**Andrew Beattie - Fw: PLEASE - BERRY RIDING CLUB URGENTLY NEEDS YOUR HELP**

**The Issues Associated with the Design of the Proposed Relocation of the Berry Equestrian Centre**

This submission concerns the impact of the proposed Foxground and Berry Bypass on the Berry Equestrian Centre which is located in North Street Berry.

RELOCATED PONY CLUB
AREA (INDICATIVE ONLY)

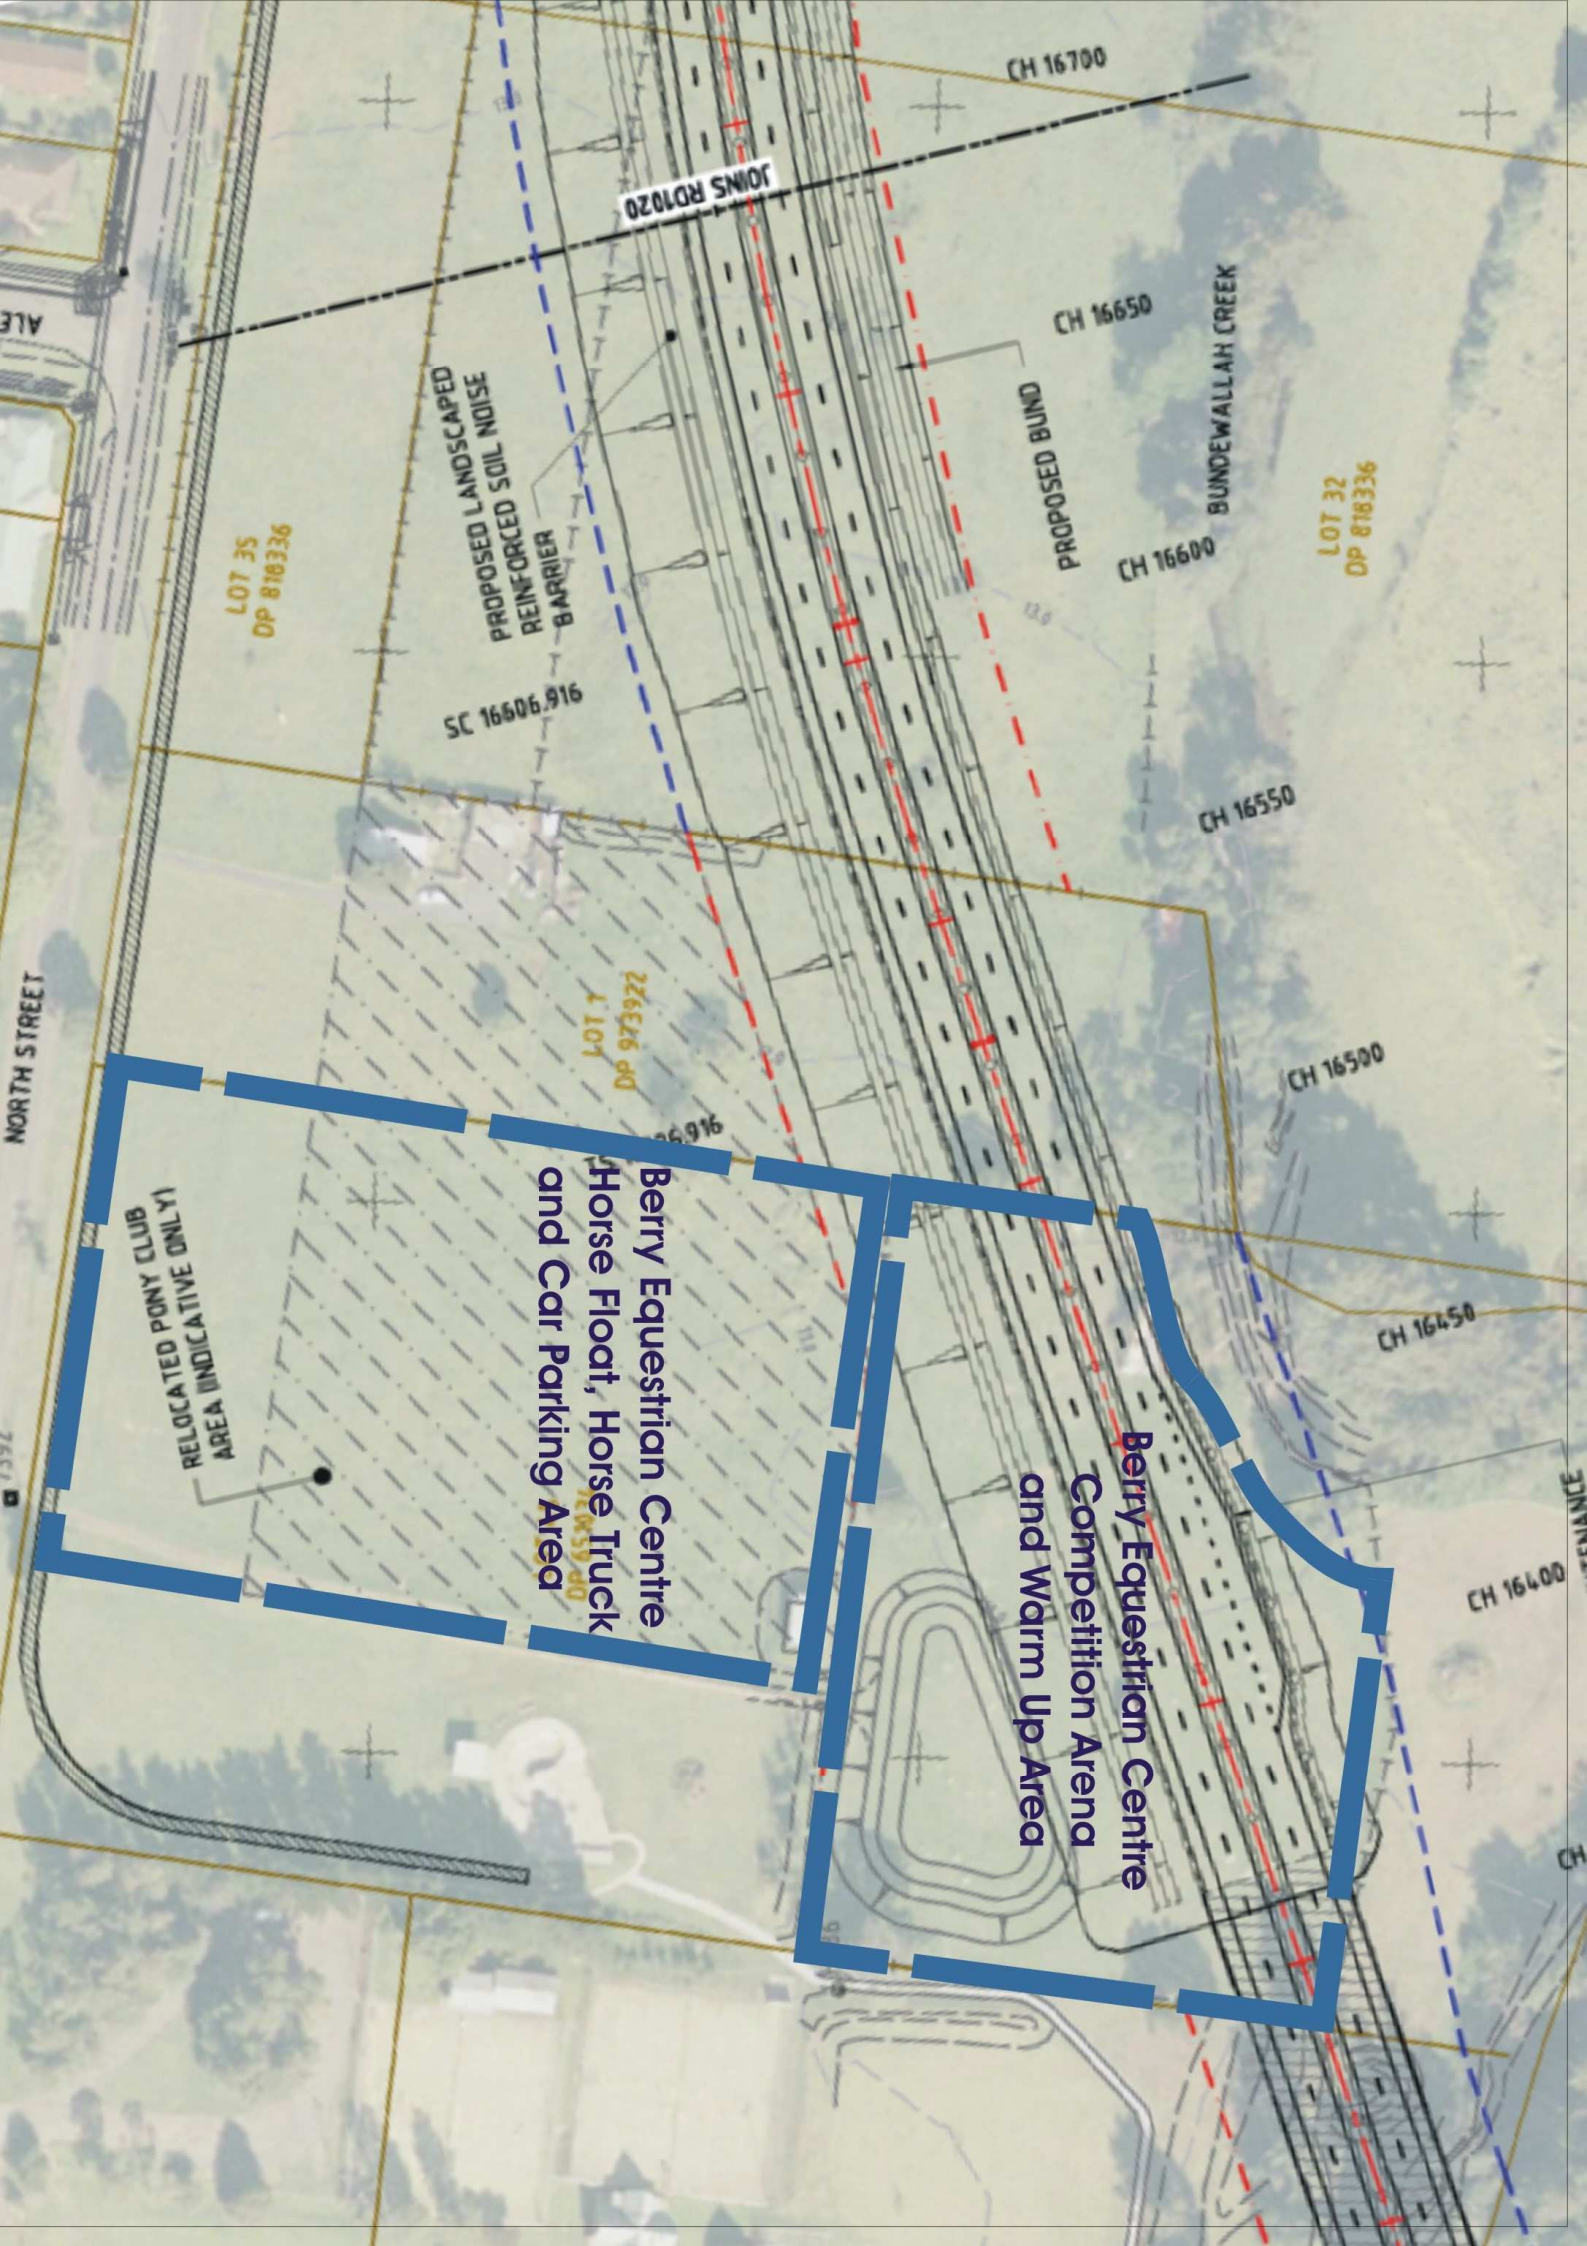
1. The competition grounds are required to be rectangular /square in shape of a minimum size of 140 metres x 140 metres with a level, well drained, good riding surface in order to cater for at least 4 dressage arenas or 2 showjumping arenas.

2. The parking area is required to be of a minimum area equivalent to 90 metres x 160 metres and allow for easy entry, maneuverability, parking and exit of horse floats and trucks. Each parking space is equivalent to an absolute minimum of 4 normal vehicle spaces due to the need for unloading/loading and tie up areas for horses.

3. There is concern for the safety of horses, riders and the general public due to the near location of the proposed riding area to the 4 lane expressway, the skateway, the public cycleway/walkway and North Street. There will be anticipated significantly increased noise and visibility of cars and trucks travelling at 100km/hour on the expressway with horses competing nearby, often with young, very inexperienced riders.

4. Access to the grounds is likely to be across a public shared cycleway/pathway. The safety of children on skateboards, bicycles etc are at risk as horse trucks and floats cross the pathway. Horse floats and trucks also require an indented driveway of at least 15 metres to allow vehicles to park off the roadway whilst gates to the grounds are opened.
